CITY OF ALBUQUERQUE

March 5, 2014

**RE: Winrock Redevelopment Dave and Busters
Grading and Drainage Plan
Engineers Stamp Date 1/27/14 (J19D038)**

GRADING & DRAINAGE
PLAN

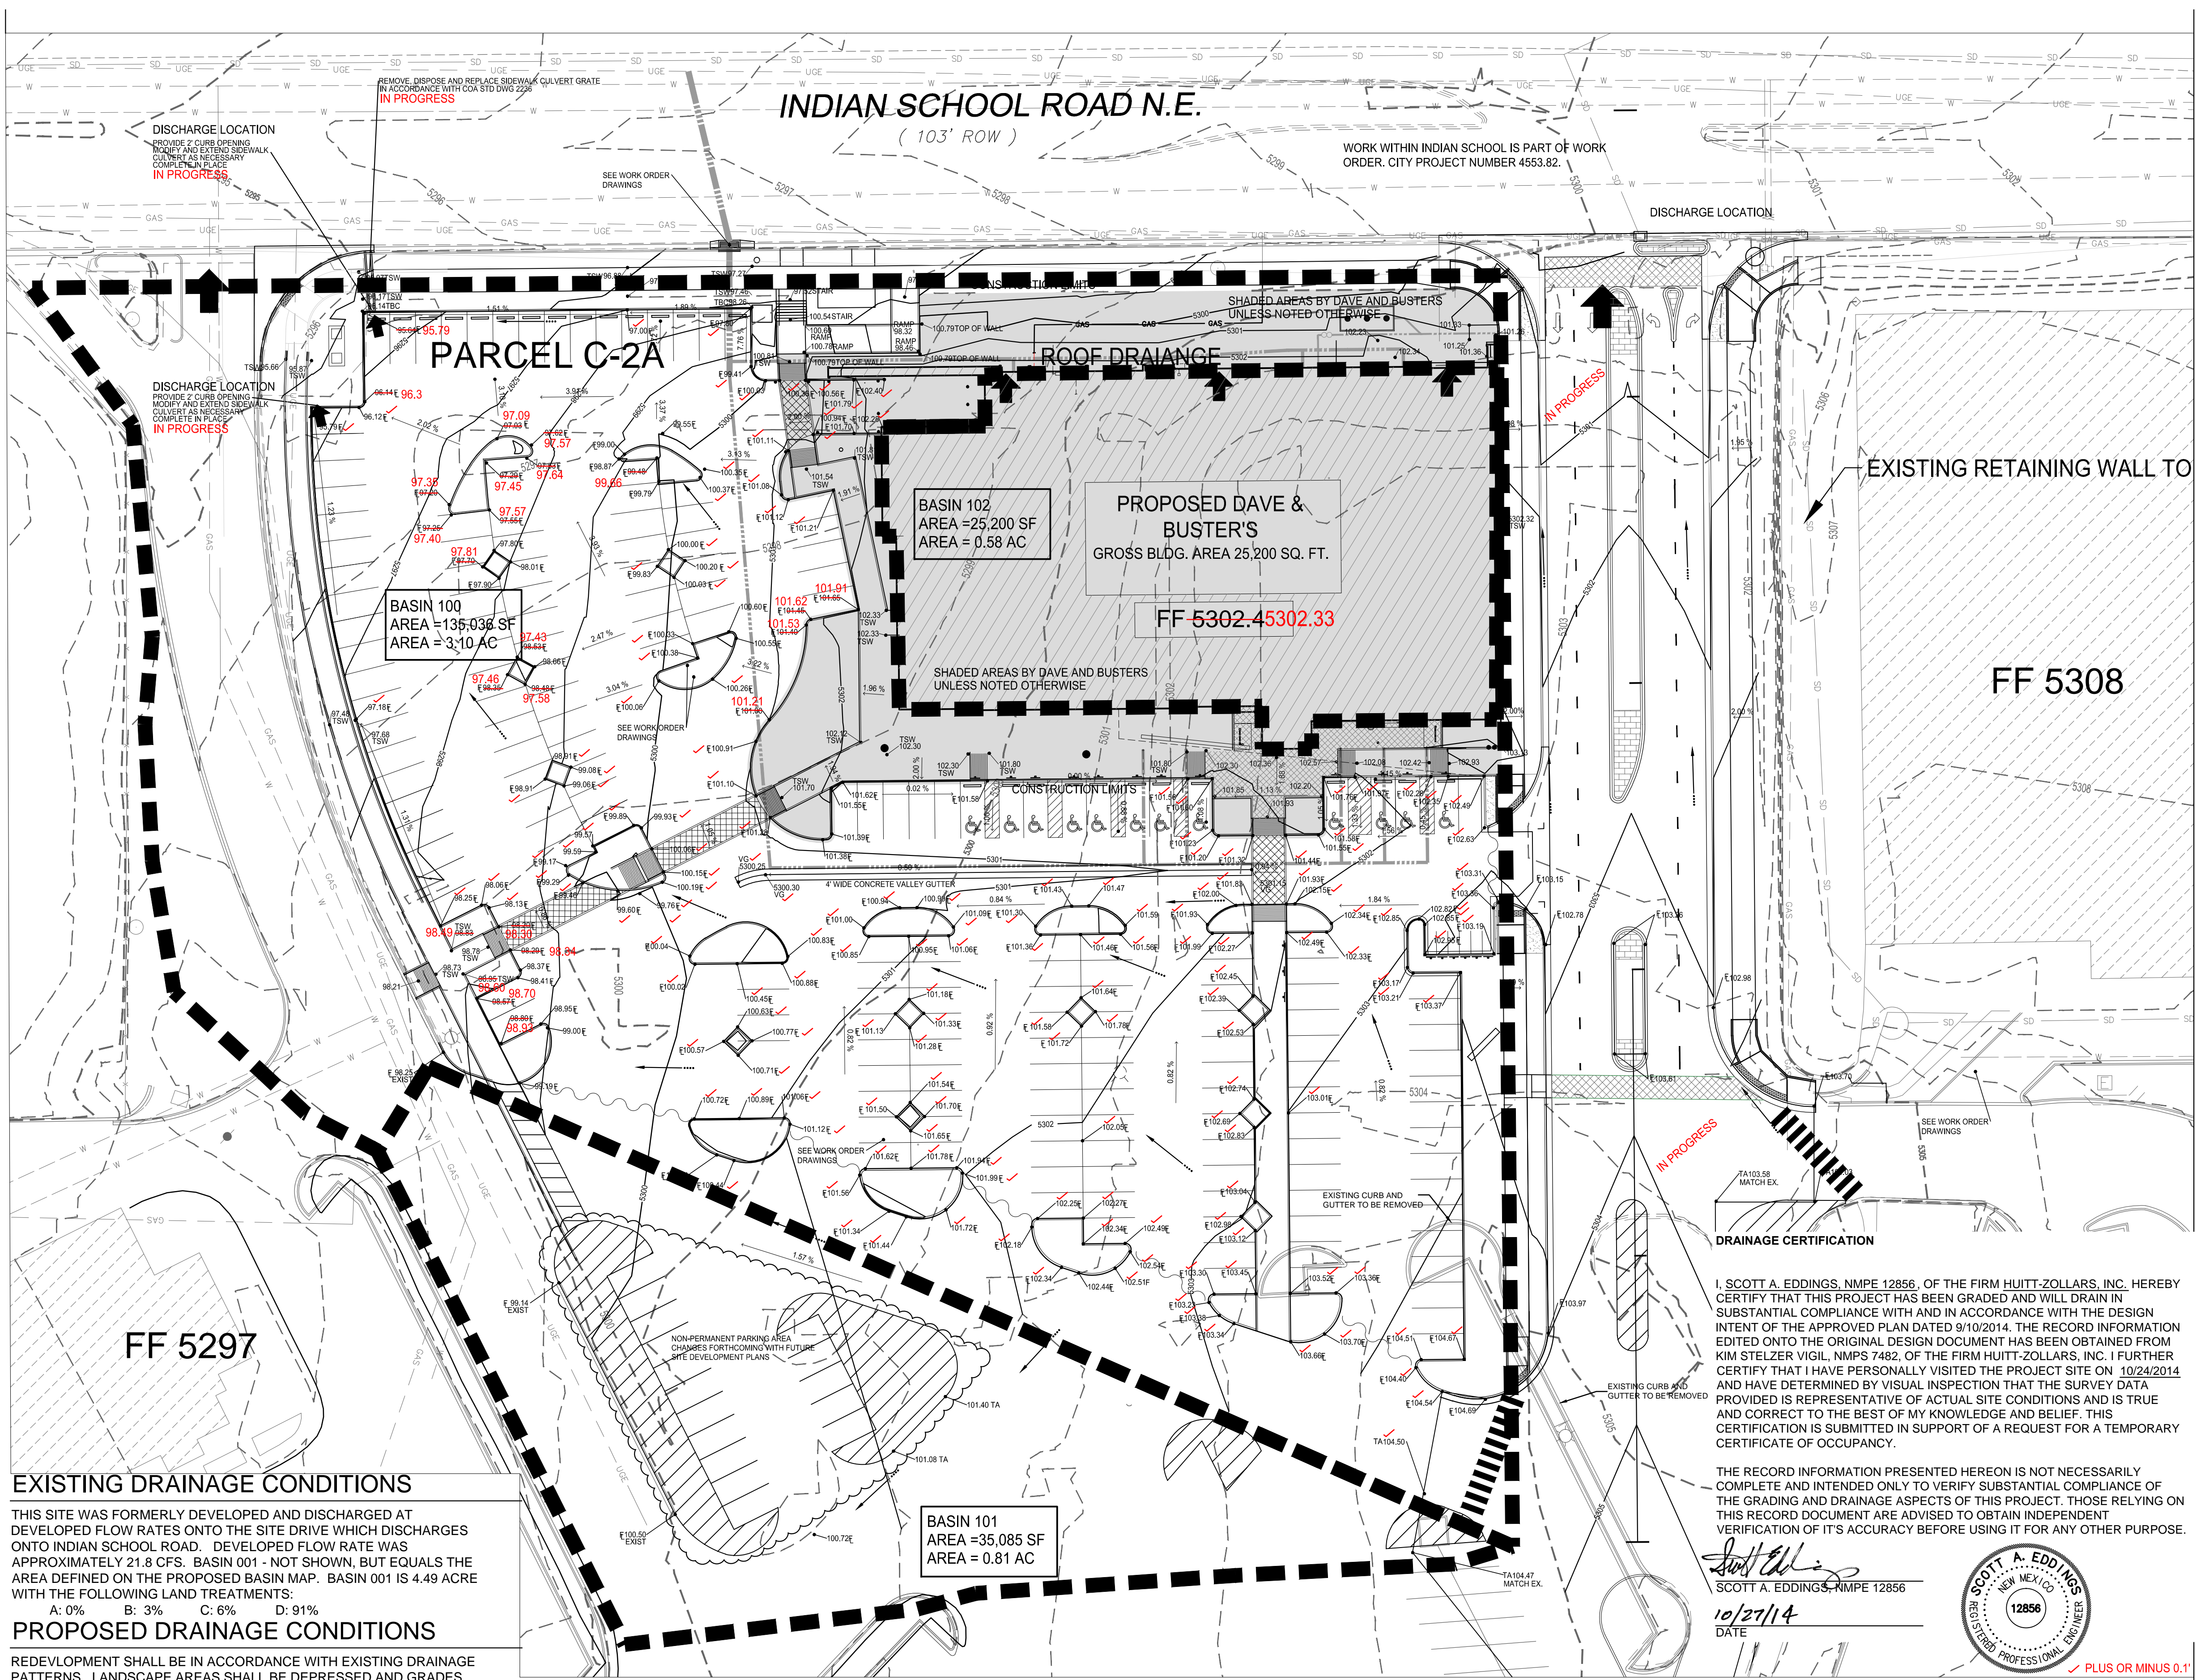
- Enlarge the utility plan to 24"x36" so it is legible or add the build notes and drainage systems to the grading and drainage plan.
- On the plan, place all drainage work that is being done in Indian School to be done by Work Order, along with replacing or repairing the sidewalk culvert. The metal cover on the sidewalk cover is in bad shape and needs to be repaired or replaced.
- Show the location of the existing inlet in the existing entrance from Indian School which is east of the site. Is this inlet being replaced, repaired or removed? Show flow lines at this location. The Island appears to be in the valley gutter, which will divert flows away from the curb and into the street. Adjust this island to prevent this situation.
